The Sizewell C Project

9.54 SZC Co. Comments on Submissions from Earlier Deadlines (Deadlines 2-4)

July 2021

DRAWING TITLE:
MAIN DEVELOPMENT SITE
KEY PLAN
RULE 17 REQUEST FOR FURTHER INFORMATION

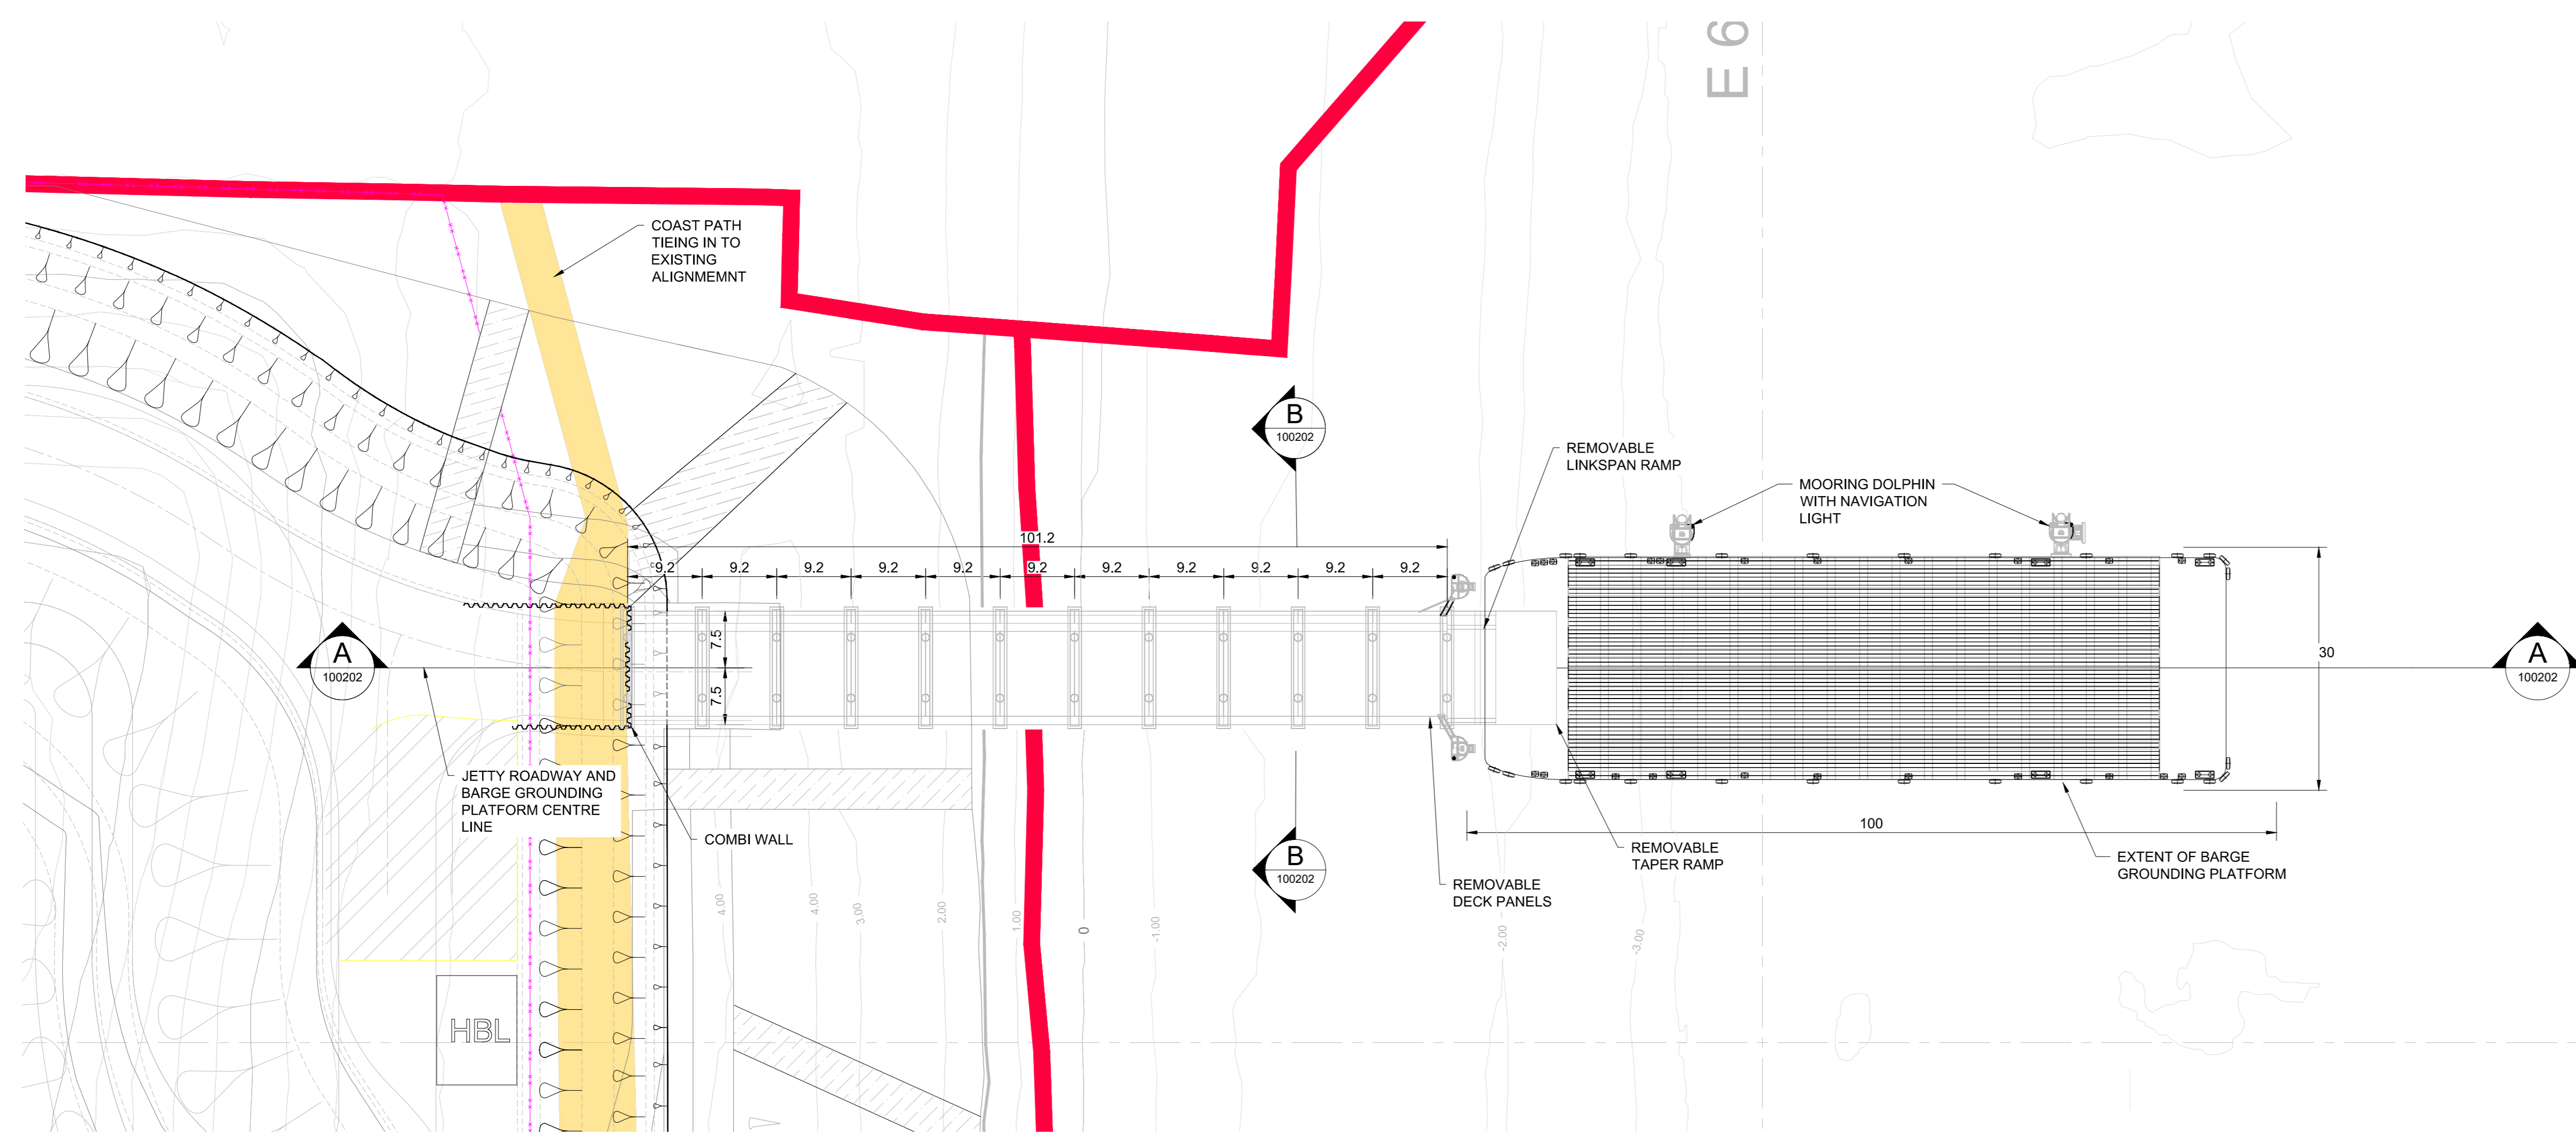
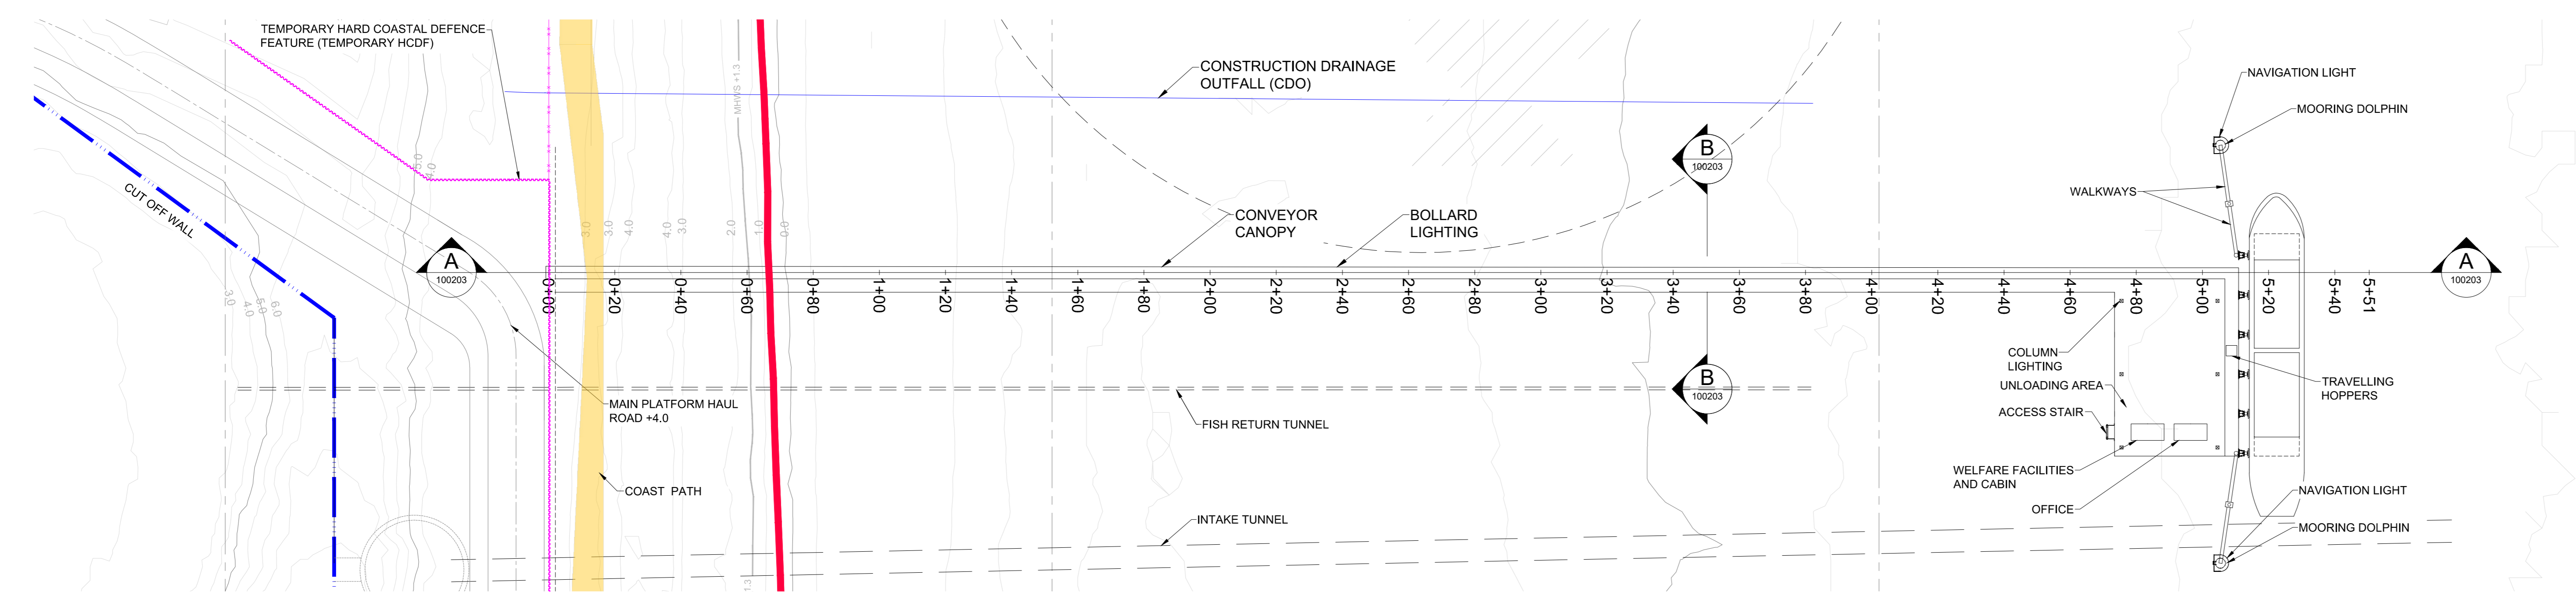
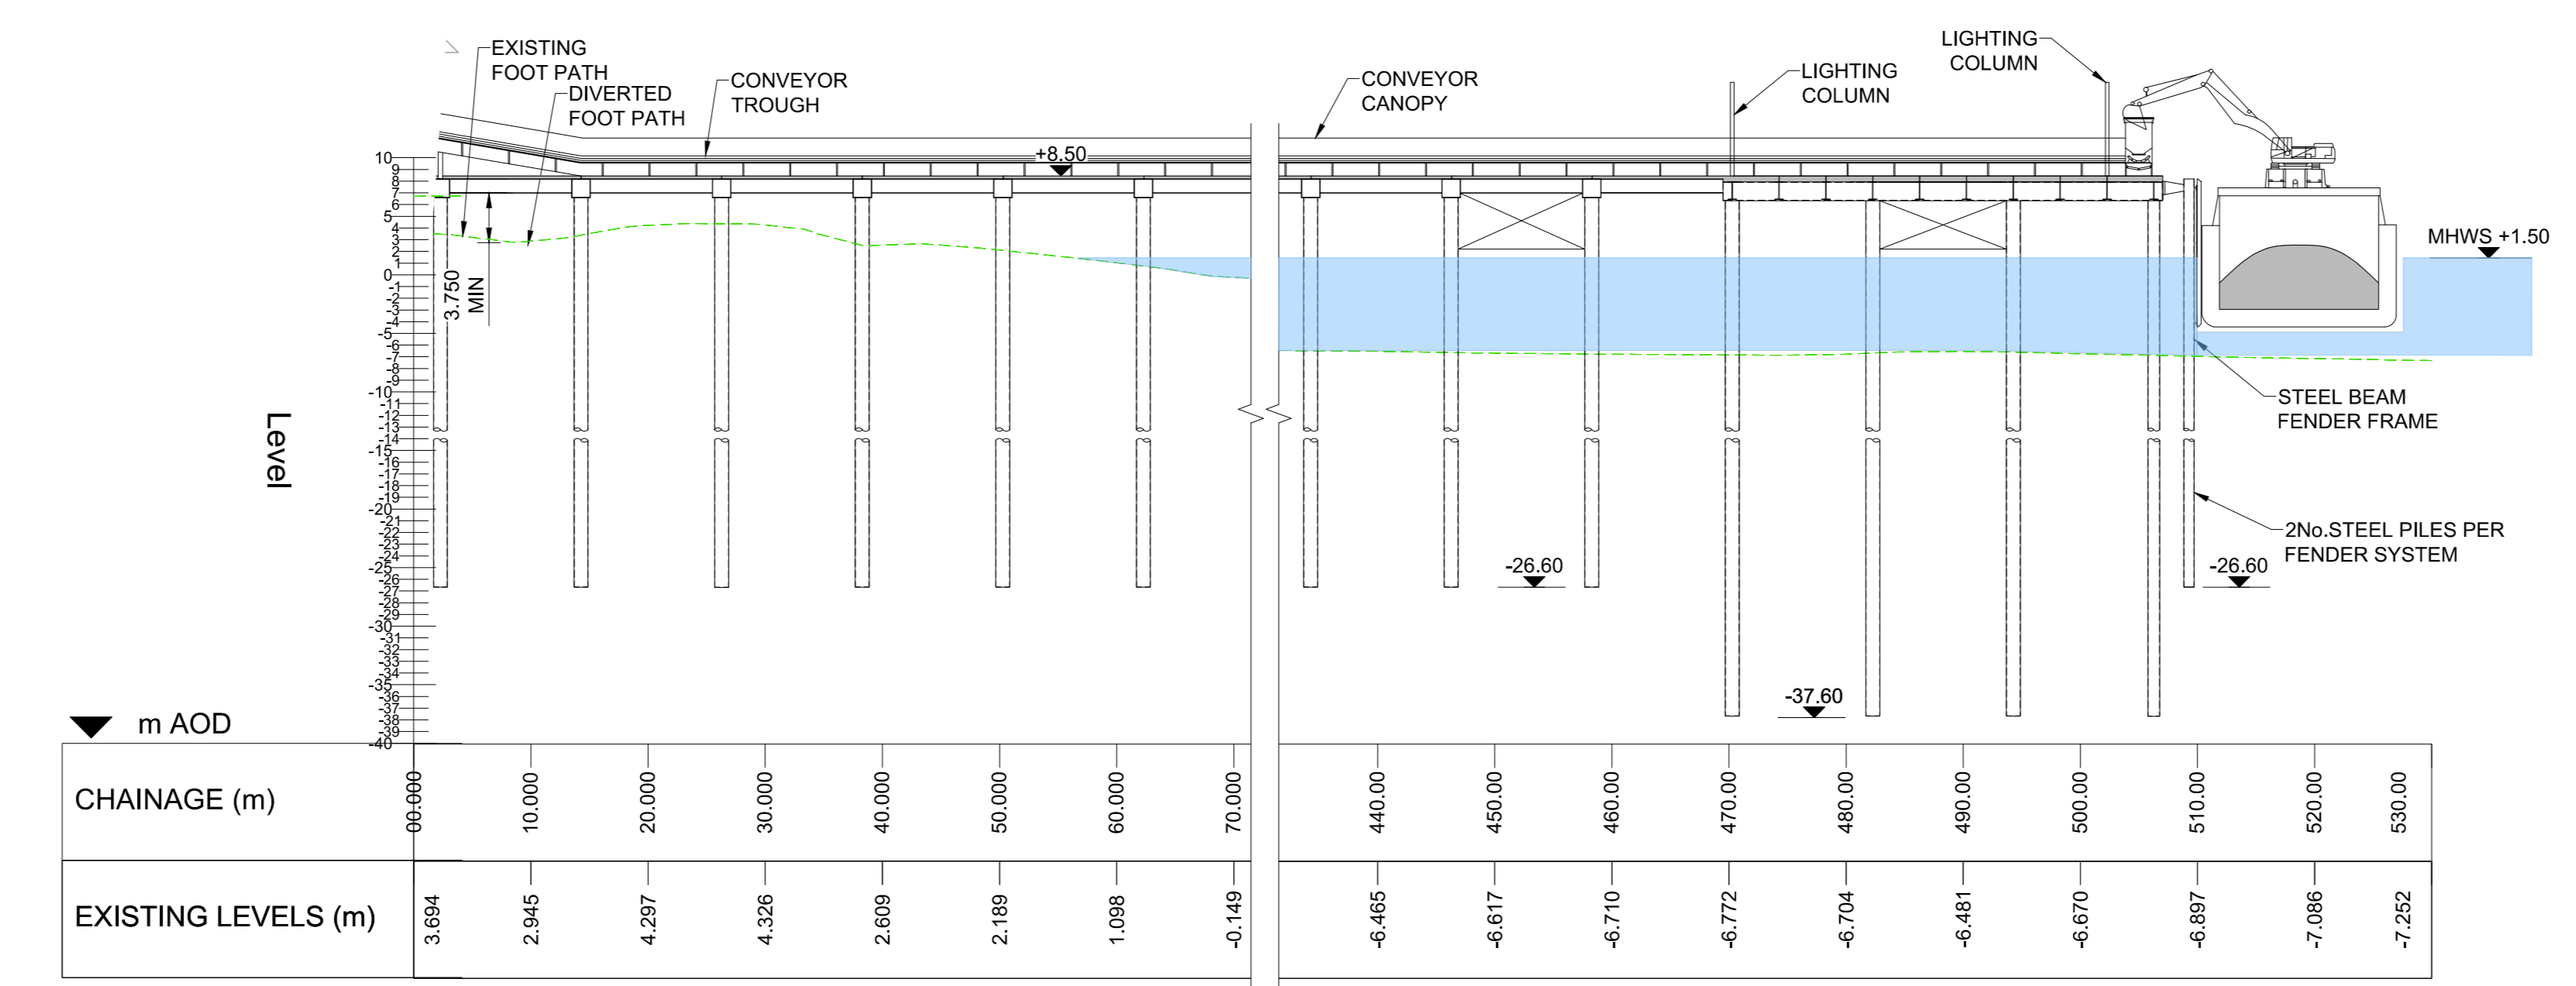
2.2.14 RSPB and SWT requested further illustrative plans of the SSSI Crossing. Updated **SSSI Crossings Plans** (Doc Ref. 2.5(A)) are submitted at Deadline 5, together with further details on the SSSI Crossing.
